Please ask for: Ms Iqraa Malik
Email: iqraa.malik@terraquest.co.uk
Telephone: 01212341390
Our Ref: FG/89/21/HH
Your Ref:
Date: 19th May 2021

Application for Planning Permission for Works or Extension to a Dwelling

Development: Rear extension including pitched roof alterations,
Extension of existing side dormer with flat roof.
Extension of front entrance to hallway with pitched roof and gable to side.
Location: 25 Ocean Drive Ferring BN12 5QN

Ground Floor Layout

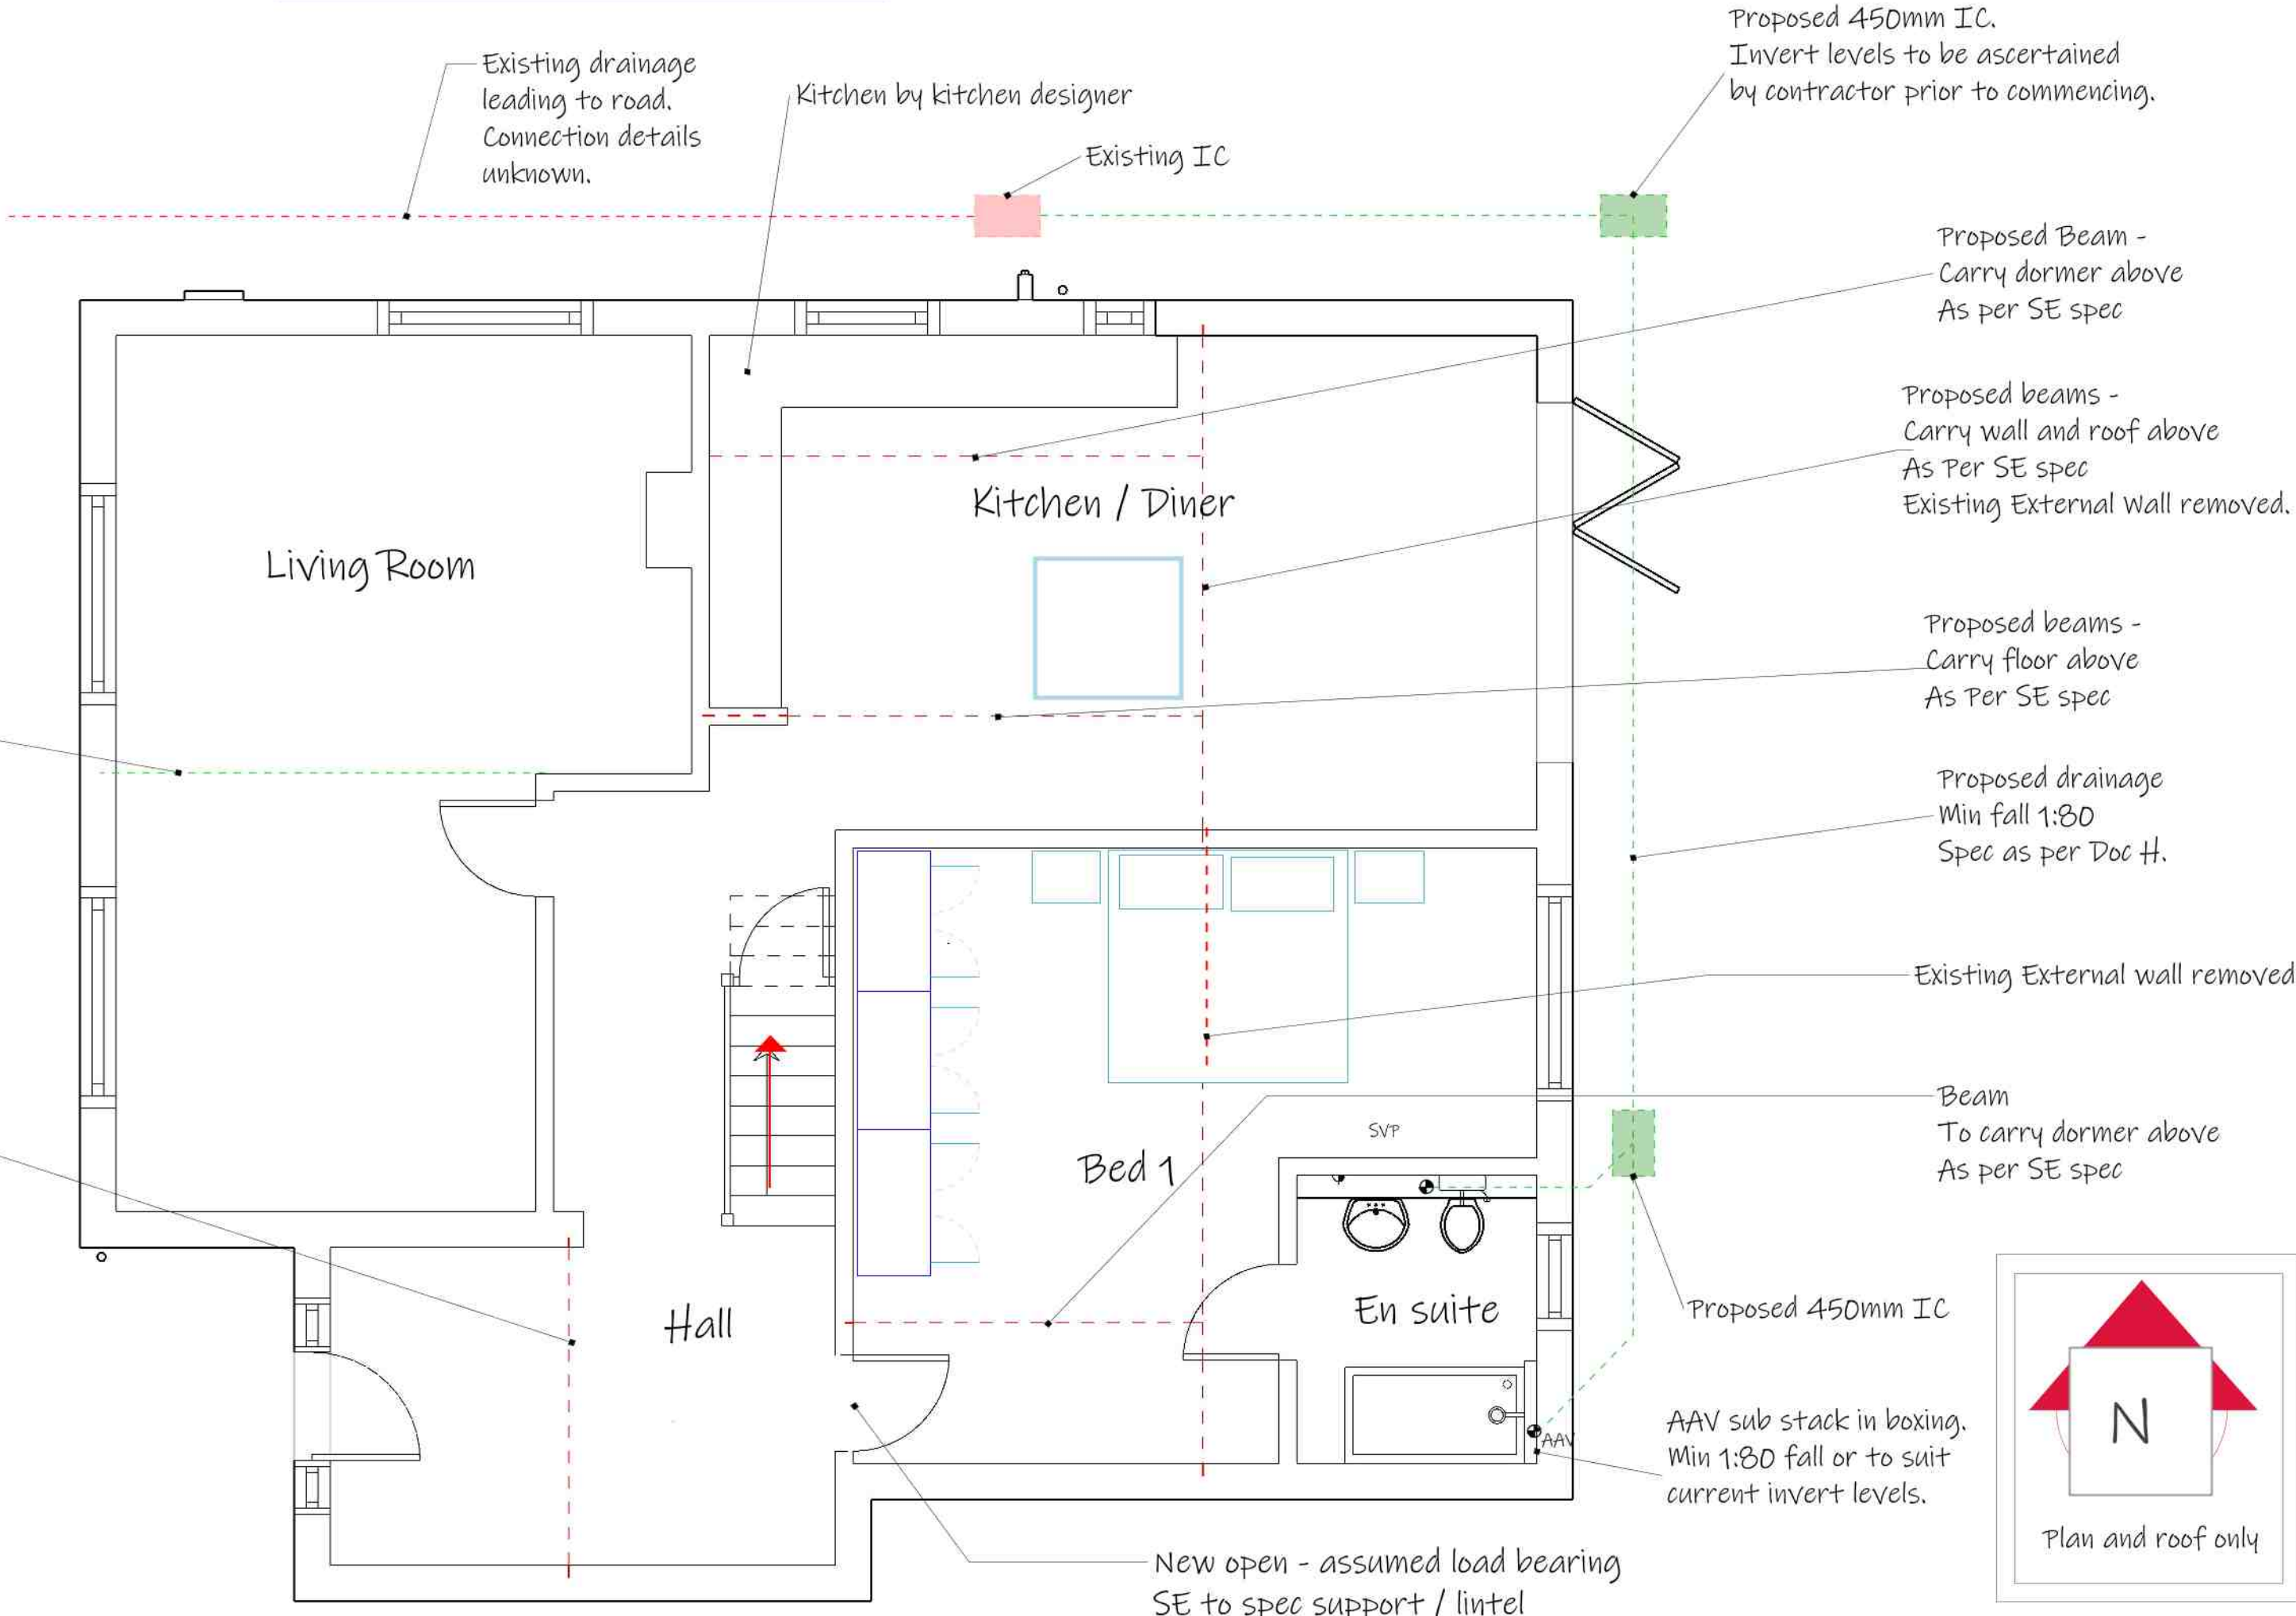
Proposed Floor Plans

Please submit a copy of clearly labelled proposed floor plans at a scale of 1:50 or 1:100. Further details can be found in the Validation Requirements List.

Room Labels

Please add room labels to all floor plans
